# CITY OF ALBUQUERQUE

**Re: Oso Bio Syringe Line  
4401 Alexander Blvd. NE  
Traffic Circulation Layout  
Engineer's Stamp 7-31-17 (F16D003B1)**

Based upon the information provided in your submittal received 8-9-17, the above referenced plan cannot be approved for Building Permit until the following comments are addressed:

**TRAFFIC CIRCULATION PLAN**

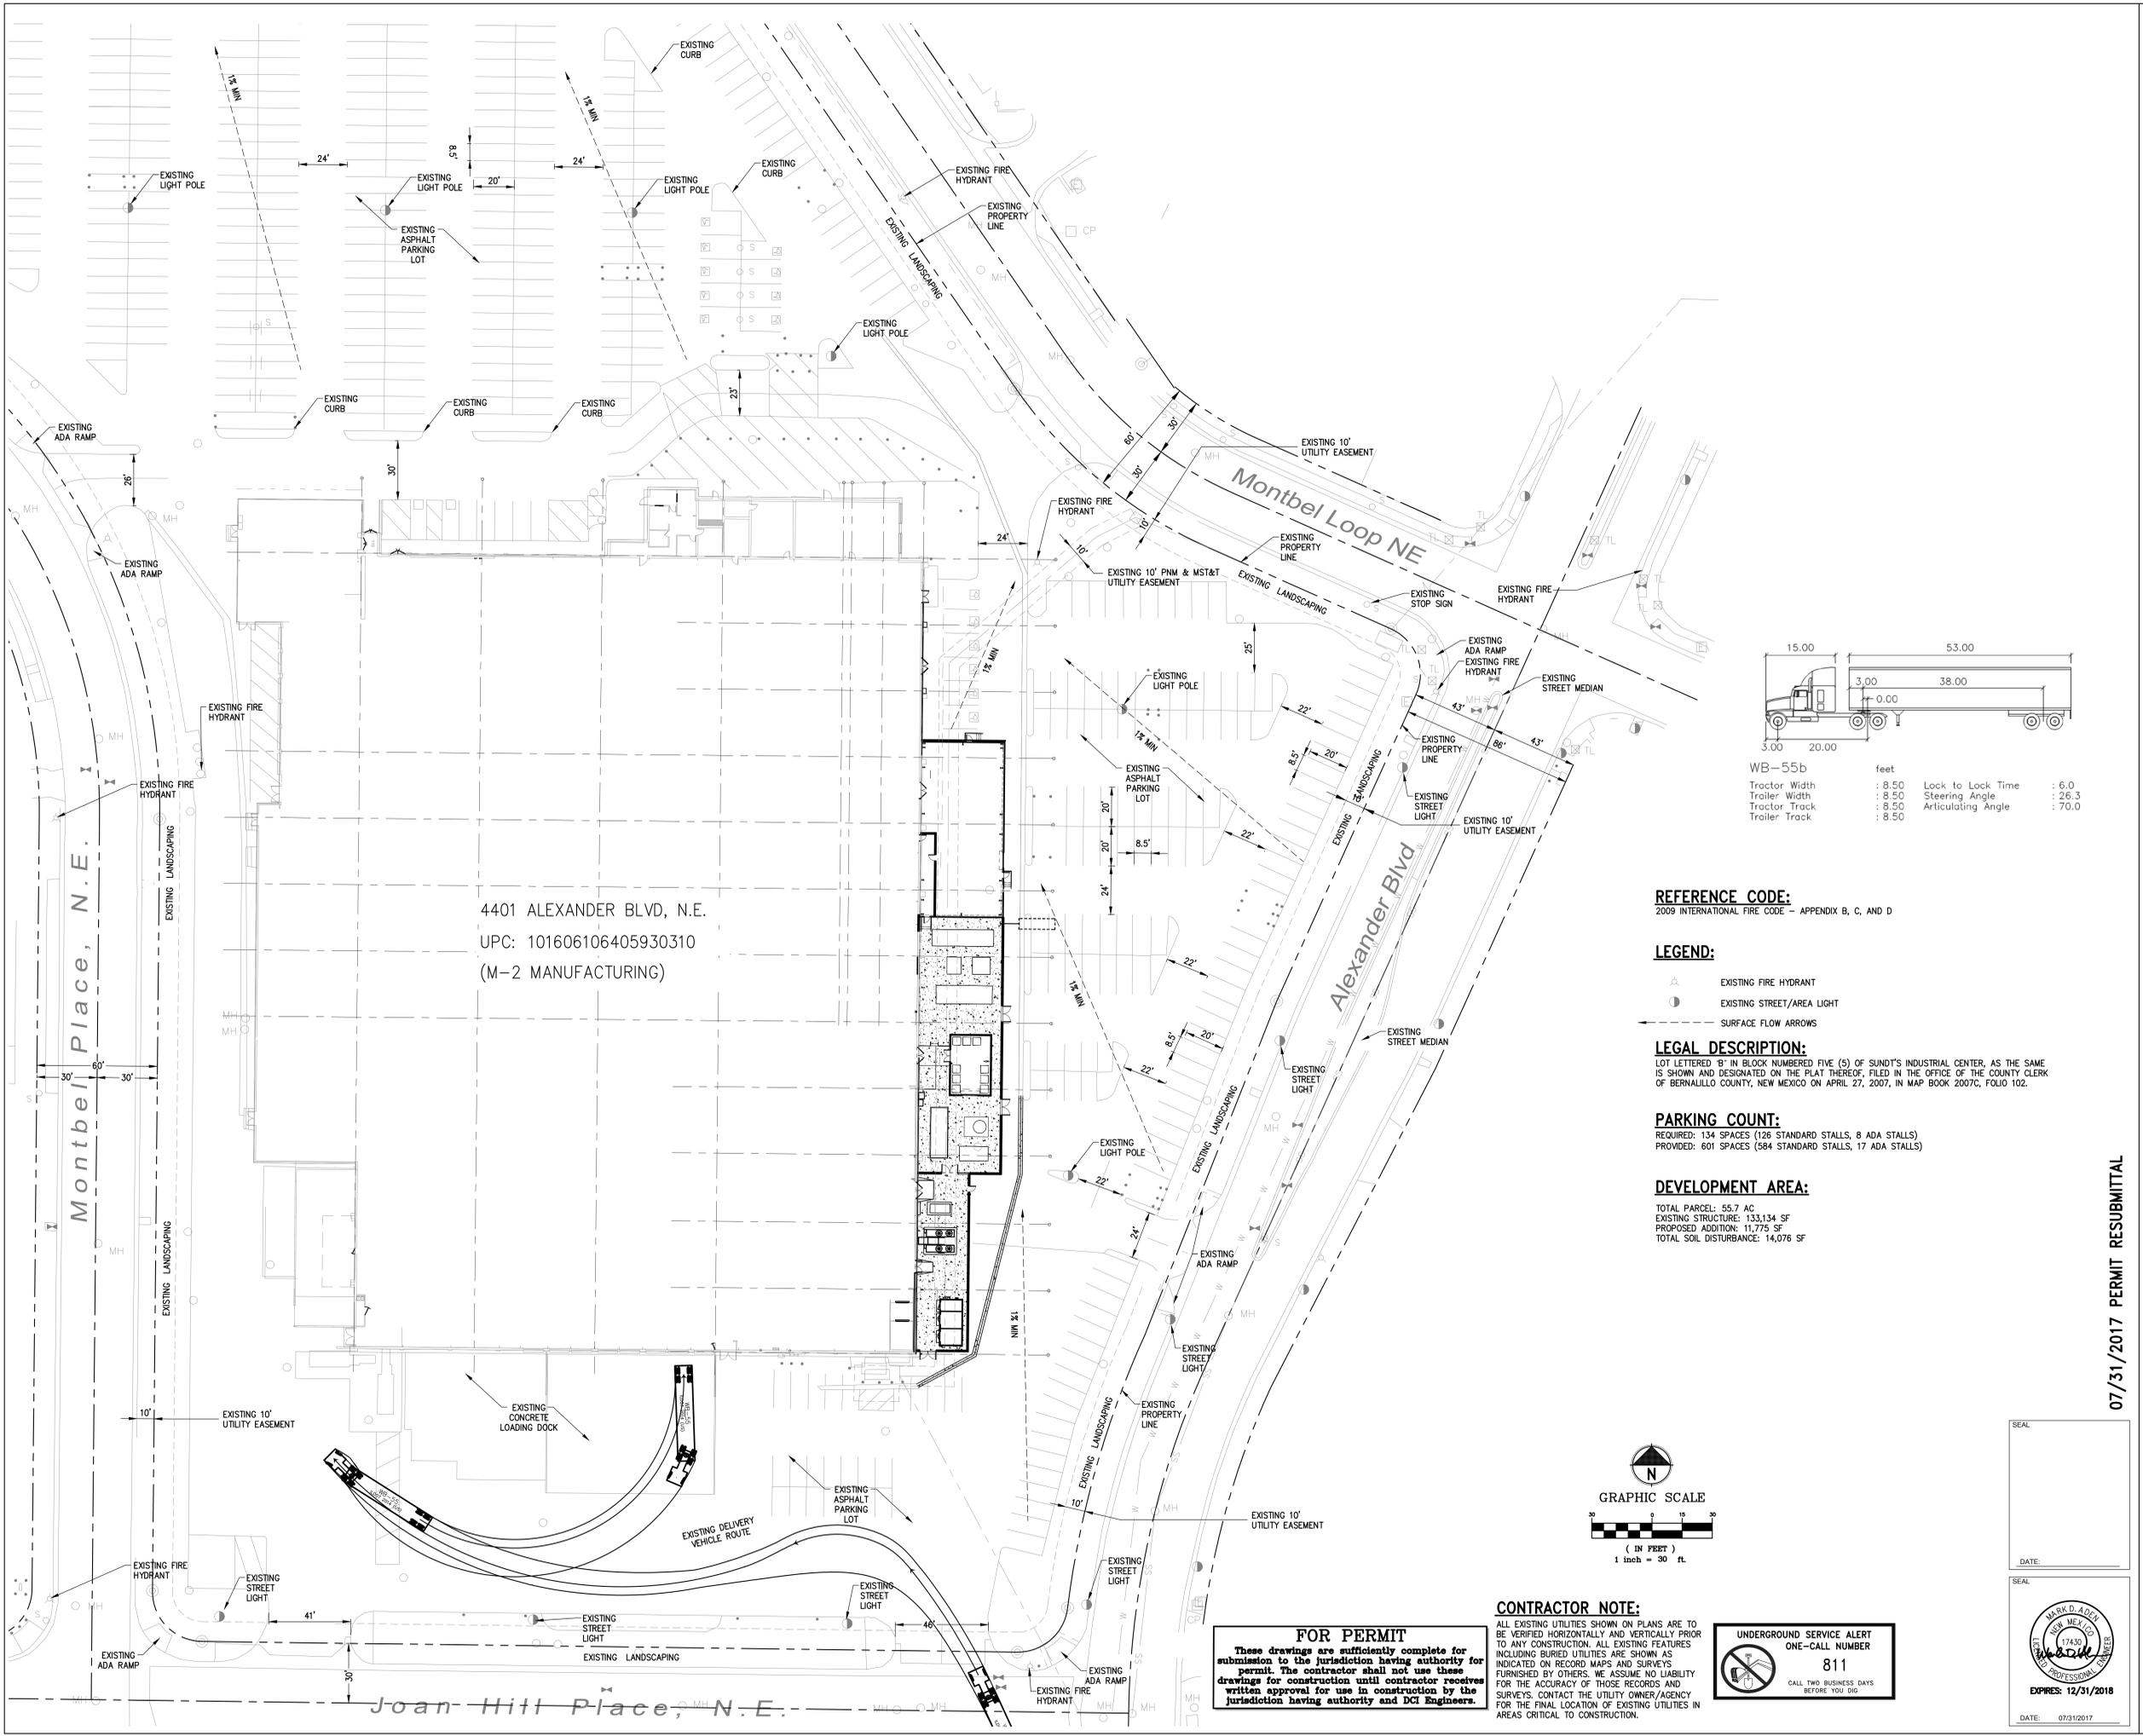
1. Please provide a site plan showing the entire property.
2. ADA accessible parking spaces must be updated to current ADA standards.
  - a. The handicap accessible spaces must be a minimum of 8.5 ft. in width and include an access aisle. Van accessible aisles should be 8ft wide; all others should be 5ft wide.

- b. The ADA accessible parking sign must have the required language per 66-7-352.4C NMSA 1978 **"Violators Are Subject to a Fine and/or Towing."** Please call out detail and location of HC signs.

- c. The ADA access aisles shall have the words **"NO PARKING"** in capital letters, each of which shall be at least one foot high and at least two inches wide, placed at the rear of the parking space so as to be close to where an adjacent vehicle's rear tire would be placed. (66-1-4.1.B NMSA 1978)

- d. Per DPM, a 6 ft. wide ADA accessible pedestrian pathway is required from the HC parking stall access aisles to the building entrances. Please clearly show this pathway and provide details.

- e. ADA accessible pedestrian pathway should not be placed behind parking space or adjacent to a vehicular way. Vehicle and pedestrian/wheel chair conflicts should be avoided as much as possible.

3. Unused curb cuts must be replaced with sidewalk and curb & gutter. A build note must be provided referring to the appropriate City Standard drawing.

4. Identify the distance from the proposed building to the end of the parking aisle island.
5. Per the zoning code, a 6 ft. wide ADA accessible pedestrian pathway is required from the public sidewalk to the building entrances. Please clearly show this pathway and provide details.

6. ADA curb ramps on frontage of property must meet current ADA requirements and should have detectable warning surface/ truncated domes that meet current ADA standard.
7. Sidewalk will be required on frontage of property. All sidewalks along streets should be placed at the property line.
